Your reference: SSD 5373
Our reference: DOC12/48939
Contact: Sarah Deards, 9995 6816

**EPA Submission - Public Exhibition of UNSW Materials Science and Engineering Building EIS
(SSD 5373)**

Attachment 1: The EPA's comments and recommended conditions of approval for the UNSW Materials Science and Engineering Building (SSD 5373)

Figure 1 Site and Noise Logging Locations

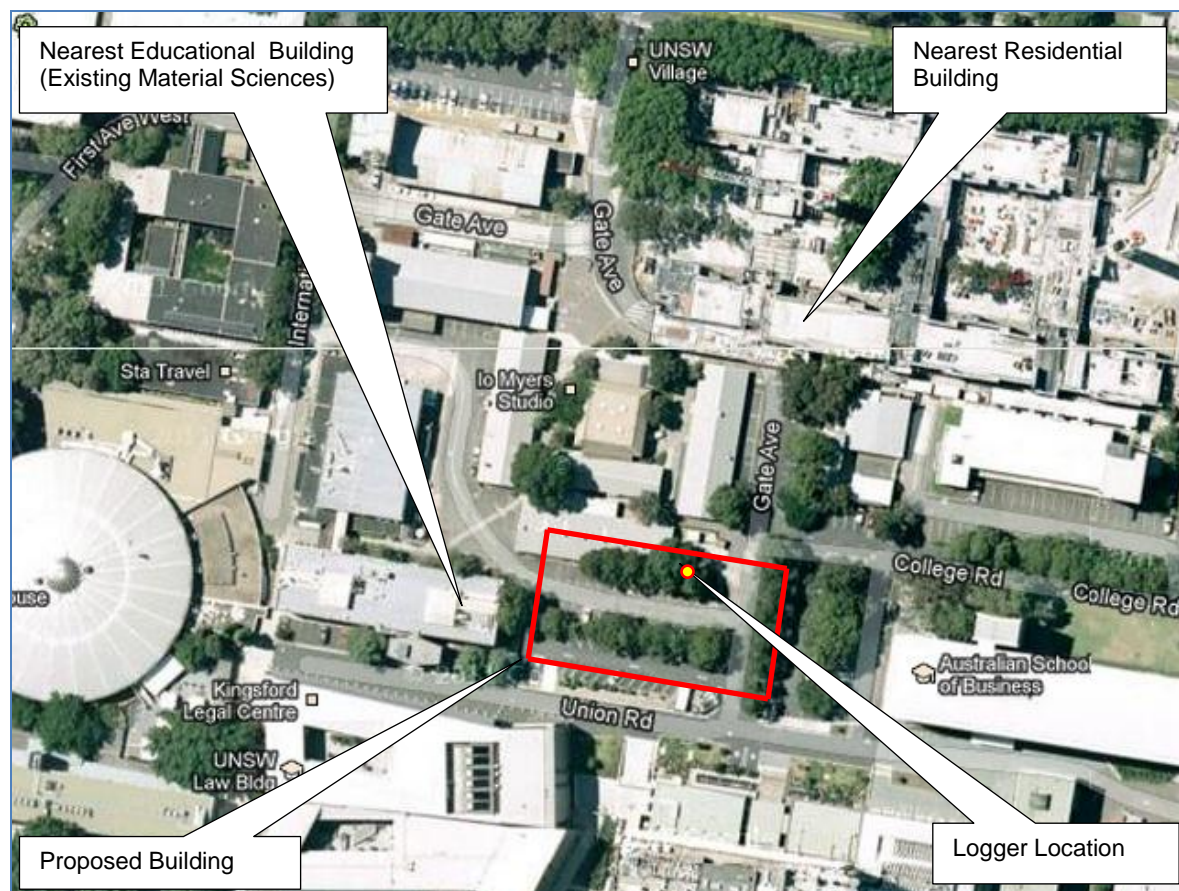
- The *Industrial Noise Policy* (EPA 2000) states that noise loggers should not be located near trees to avoid noise from wind blowing through foliage. It appears from Figure 1 of the Acoustic Report that the long term noise logger was located beneath trees.
